From: Bennett, Richard - Communities <Richard.Bennett@Oxfordshire.gov.uk>
Sent: 22 July 2019 13:50
To: Michael Smith
Cc: Drainage - E&E; White, Joy - Communities; Renee Upton
Subject: RE: Request for Comments on Proposed SW Strategy for Development

**Figure 4-2: Site Wide Existing Drainage Network**

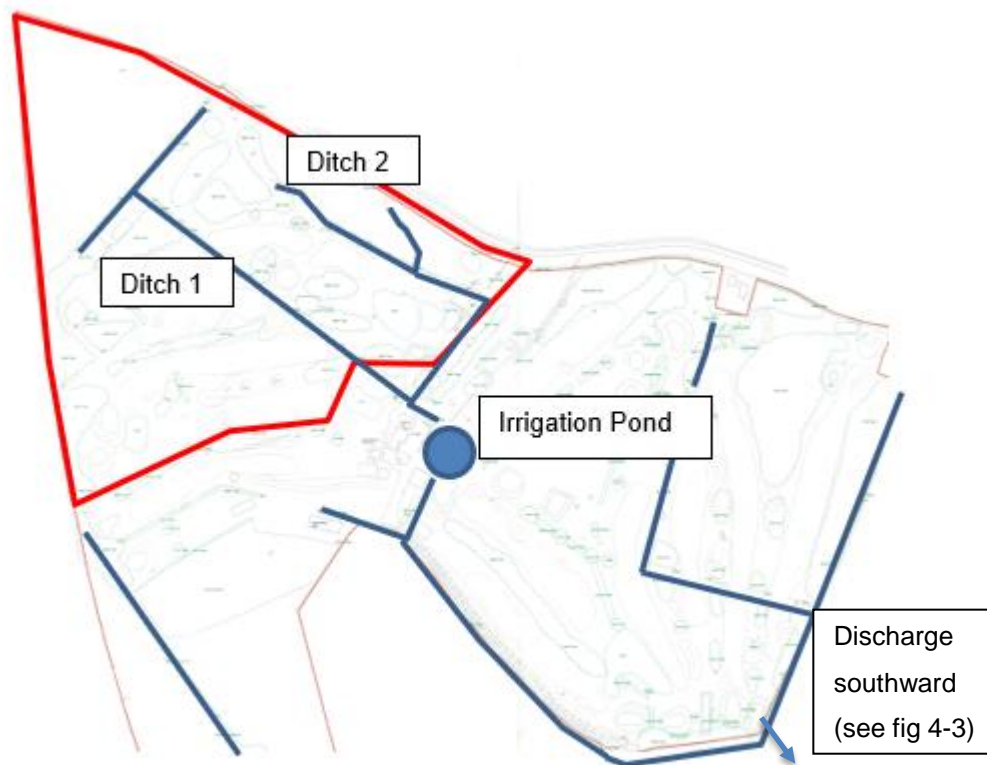
As stated in my previous comments we will expect the drainage strategy to mimic the existing drainage regime and therefore discharging at greenfield to the current outfall point will be acceptable. There are 2 existing watercourses and large pond that are currently planned to be removed and these must be retained to ensure the current drainage regime is maintained.

**Figure 5-1: QBar Calculation**

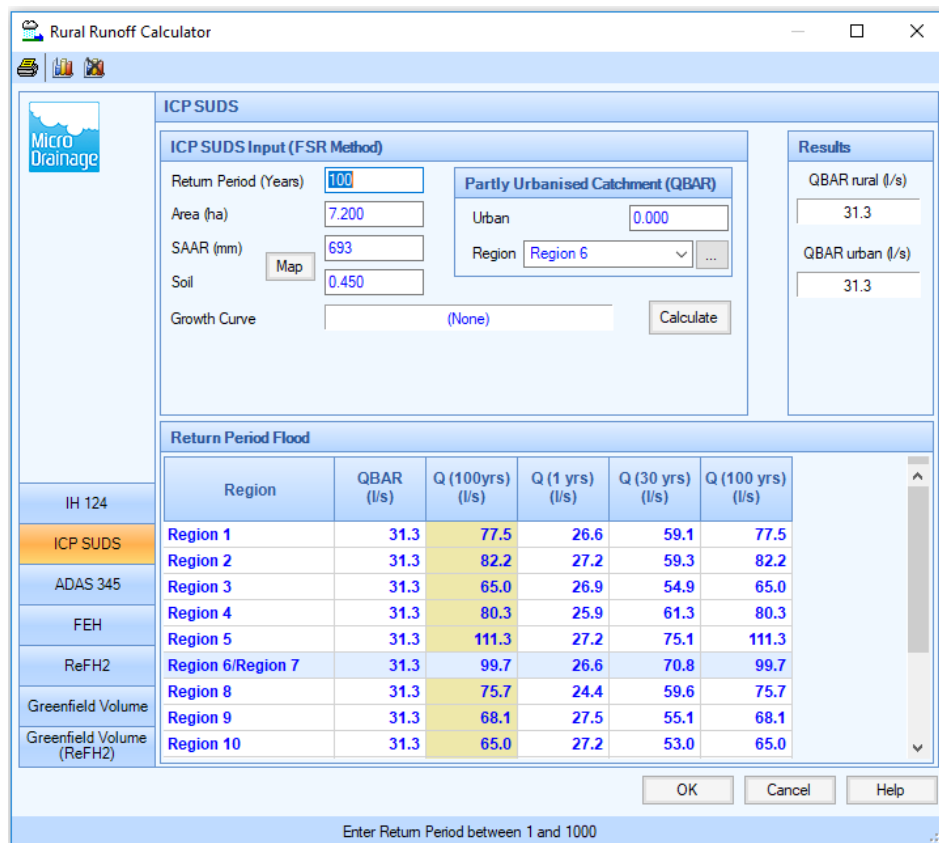
We will expect a restricted discharge to greenfield (QBAR for all events up to the 1 in 100 year event plus 40% allowance climate change) if infiltration isn't feasible. We will require evidence that infiltration isn't feasible which you state you have already obtained.
